**Sent:** 26 August 2010 13:43  
**To:** Planning  
**Subject:** S6/2910/1711/FP Formation of replacement car parks etc

Planning application S6/20/2010/1711/FP

My comments relate only to the proposed Viaduct carpark. I suggest it would be appropriate to require additional work by the applicant before the application is put before the Planning Control Committee.

DRAWING NUMBER:
045-VC-002 B

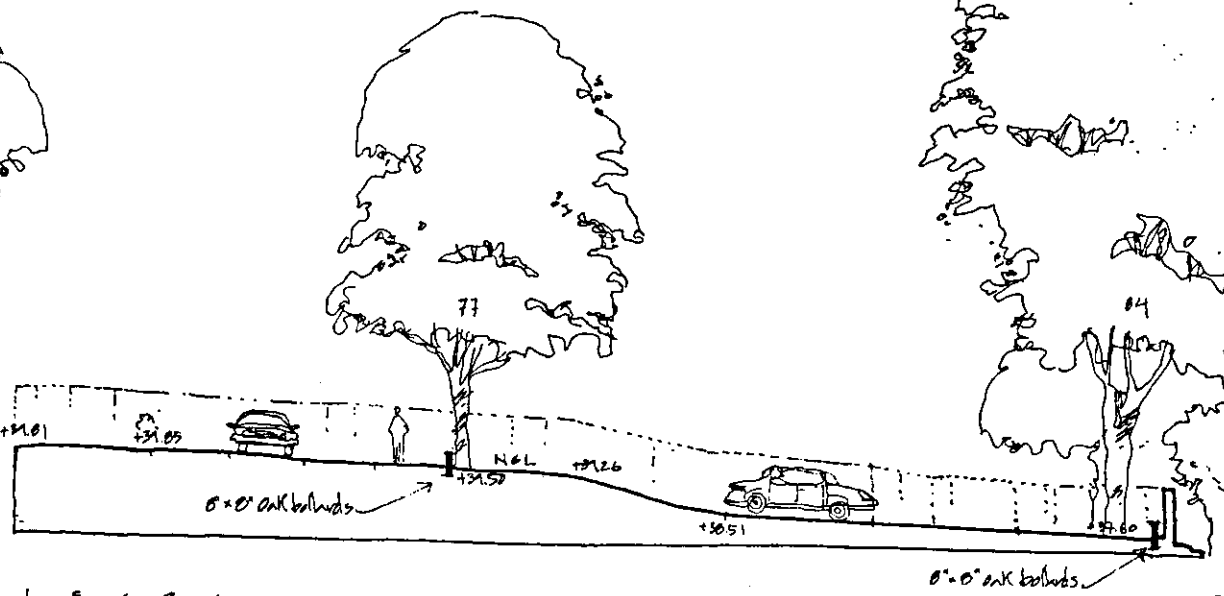
What is the route by which vehicles would enter and leave the carpark? What happens beyond the gate shown on the sketch in connection with a proposed new access road? What is the extent of this access road?
